## Appeal Decision

**Appeal Ref: APP/R4408/D/23/3318802**

**3 Hall Place, Monk Bretton, Barnsley S71 2EX**

**FLOOR PLANS AND ELEVATIONS.**

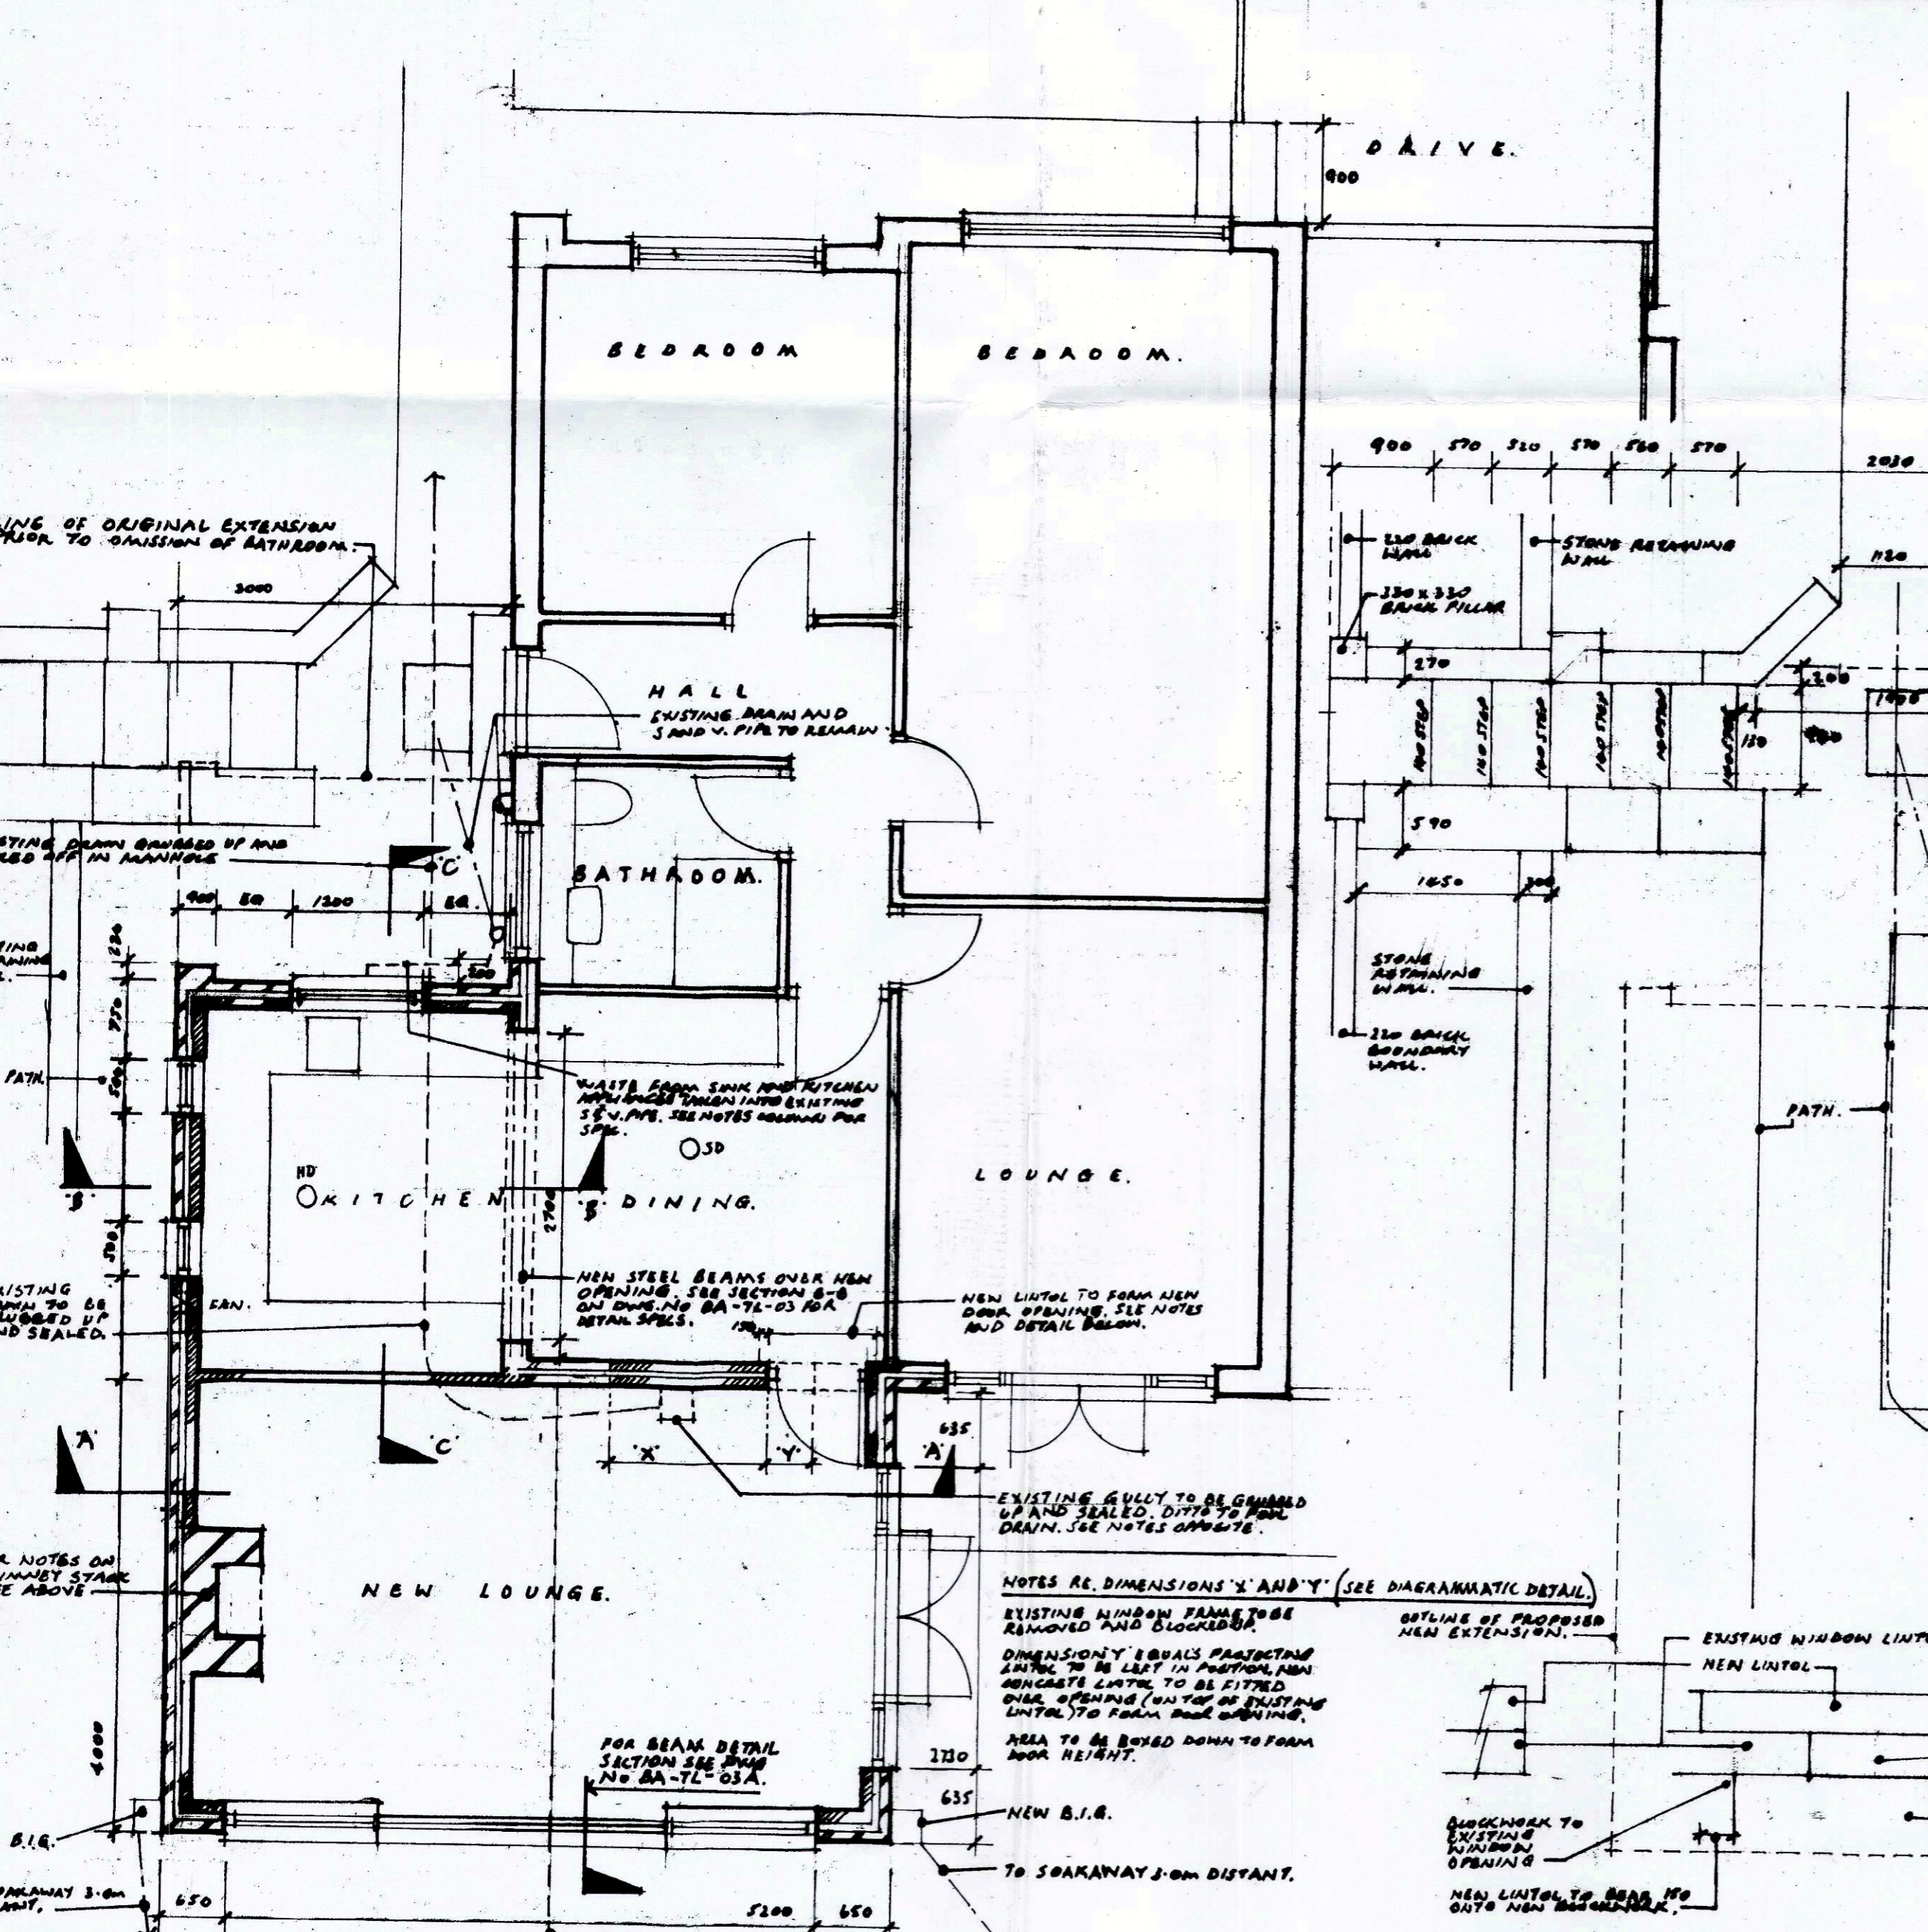
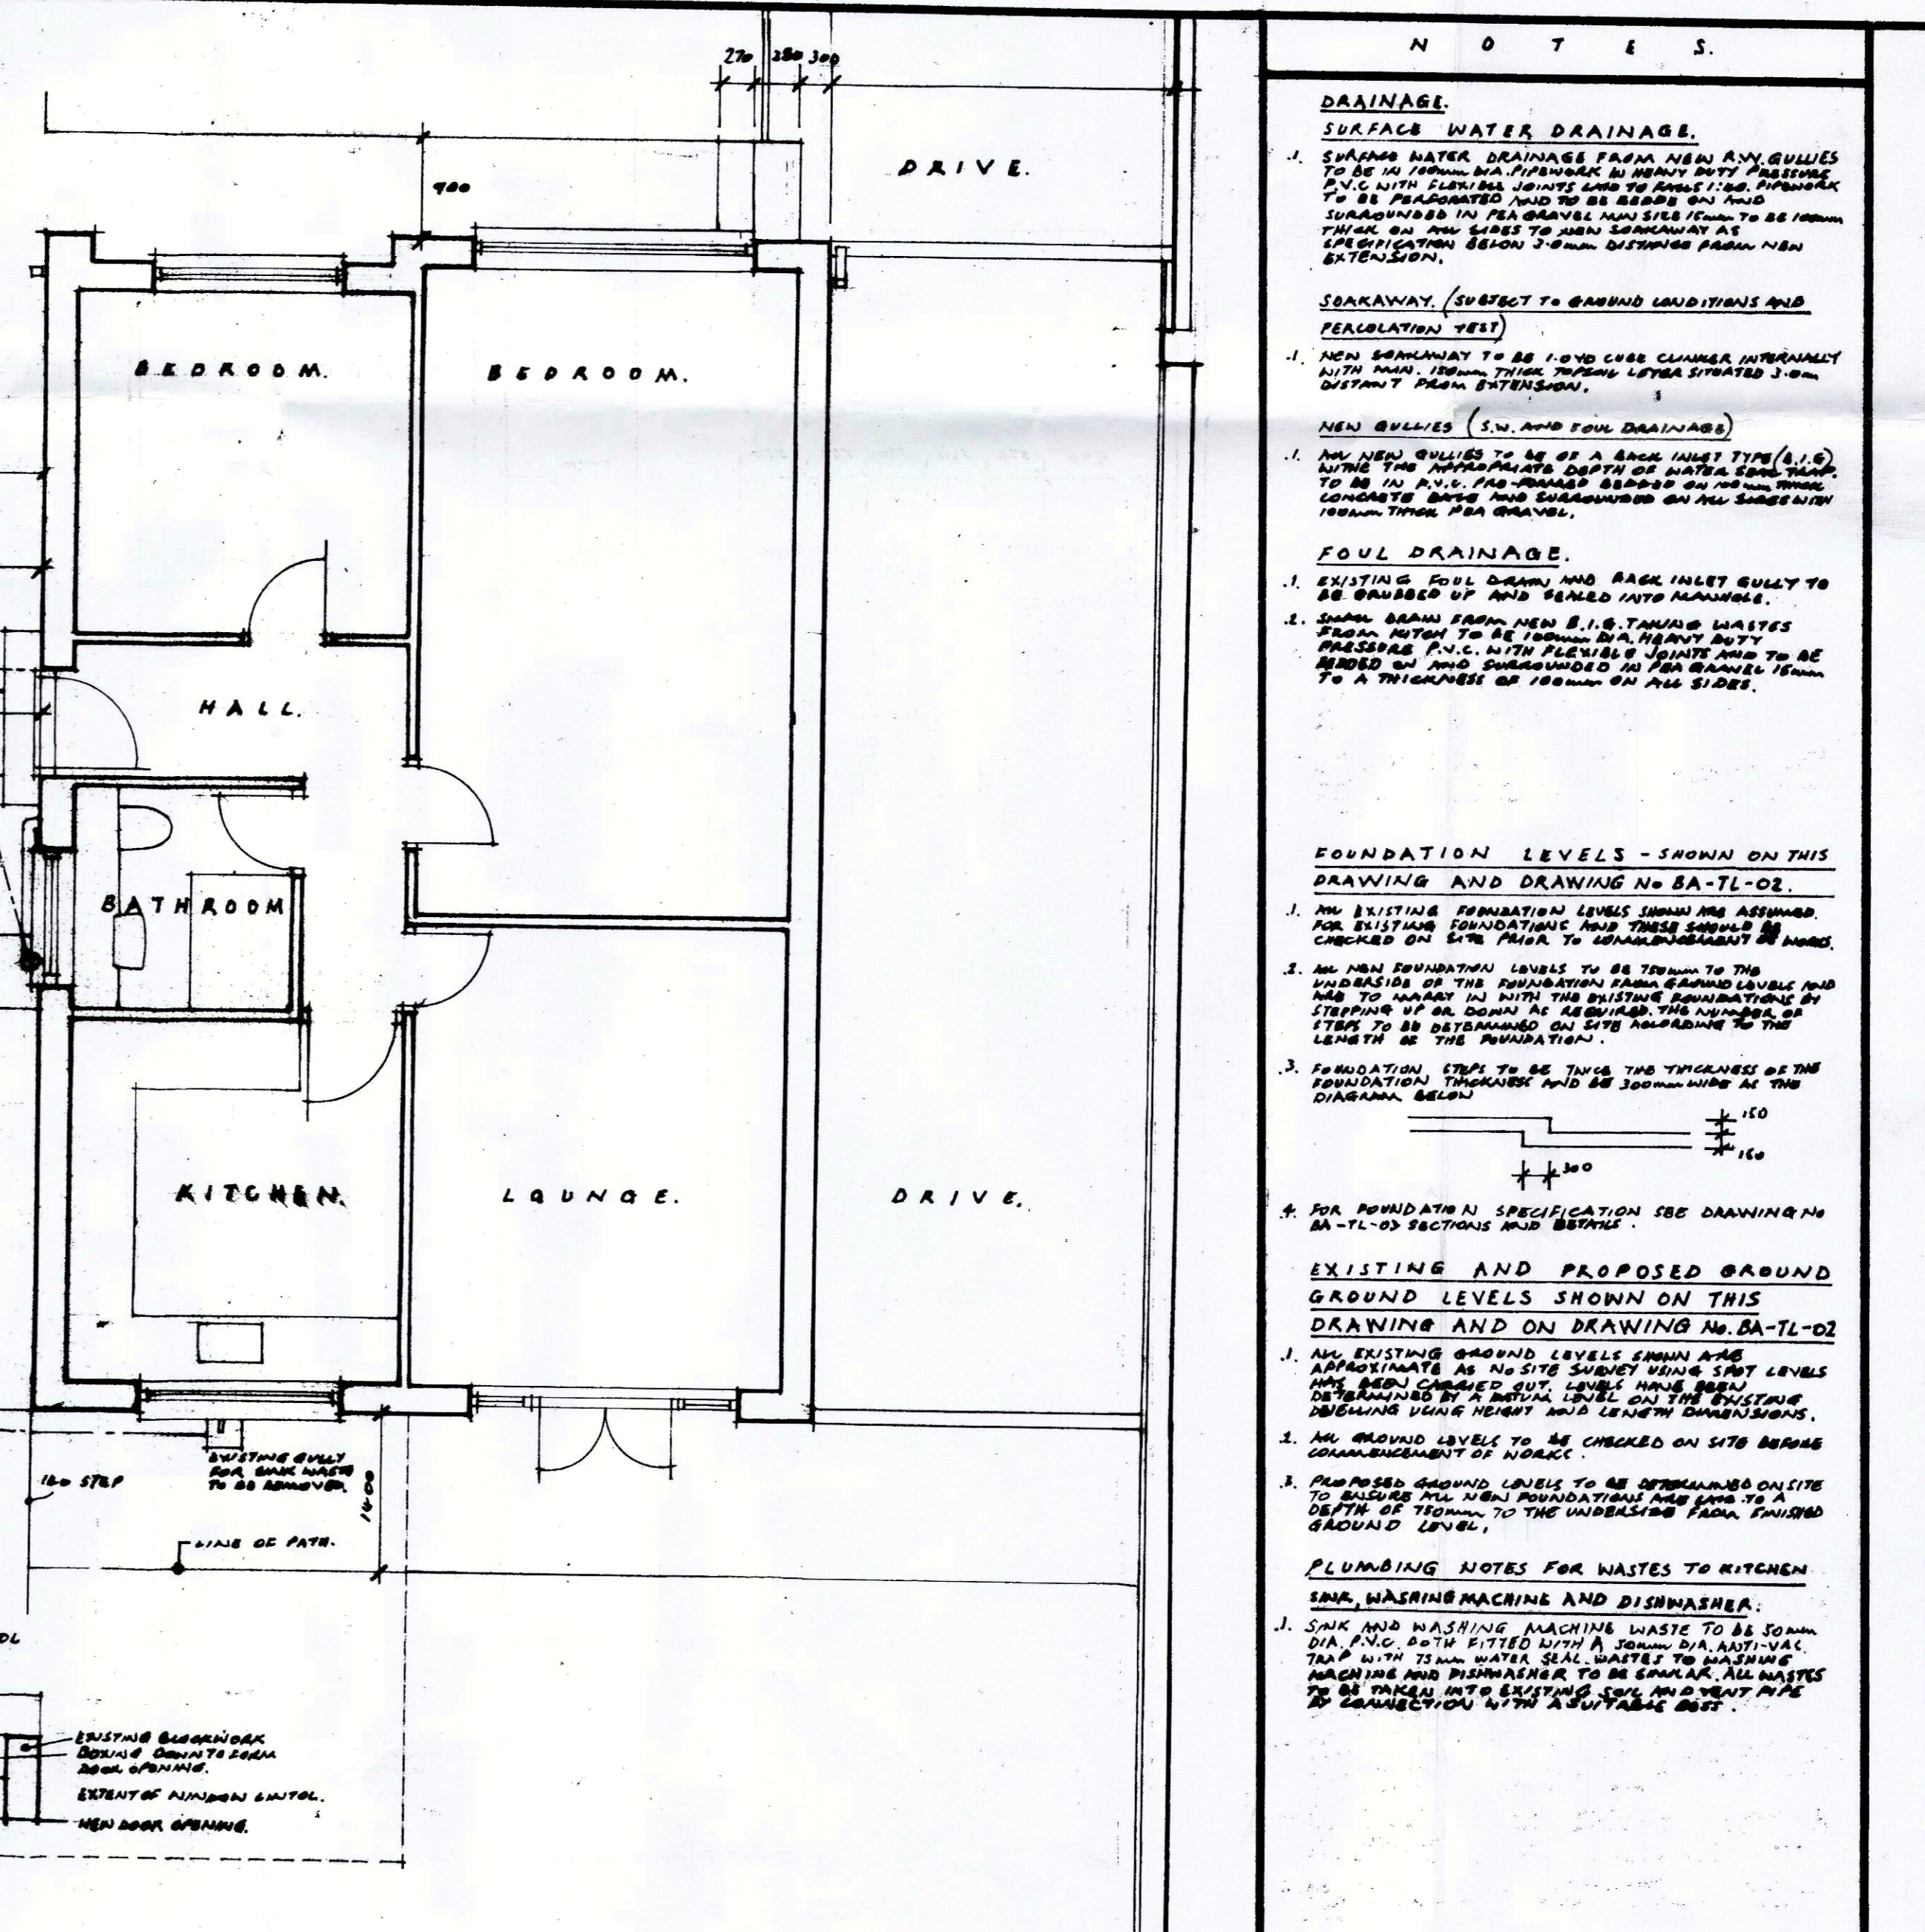
roof plane of the new single storey rear/side extension is a chimney stack that provides extract from a fireplace in the lounge. The chimney stack is brick built, around 0.8m in depth and is a height of around 1.5m from the roof plane (or 1.6m including the flue).

6. Although higher than the ridge of the host bungalow and prominent on the corner as you enter Hall Place from Cross Street, I did not find the chimney to be a particularly incongruous feature or excessive relative to the significant scale of the extended roof of the bungalow. The chimney stack has a functional appearance, but this does not equate to poor design, and the use of brick means it assimilates with its host. Further, I did not find the chimney stack to be out of keeping with the surrounding area and streetscene, which I observed on my site visit is characterised by a mix of dwelling types and styles, and includes chimney stacks of various sizes and design.

1. The appeal is allowed and planning permission is granted for erection of single storey side/rear extension and erection of chimney stack positioned on roof plane of the extension at 3 Hall Place, Monk Bretton, Barnsley S71 2EX in accordance with the terms of the application, 2022/0937, dated 6 July 2022, and the plans submitted with it, subject to the following conditions:
  - 1) The development hereby permitted shall be carried out in accordance with the following approved plans: Site Plan, Location Plan, Elevations (Revision B); and Floor Plans and Elevations (Revision C).
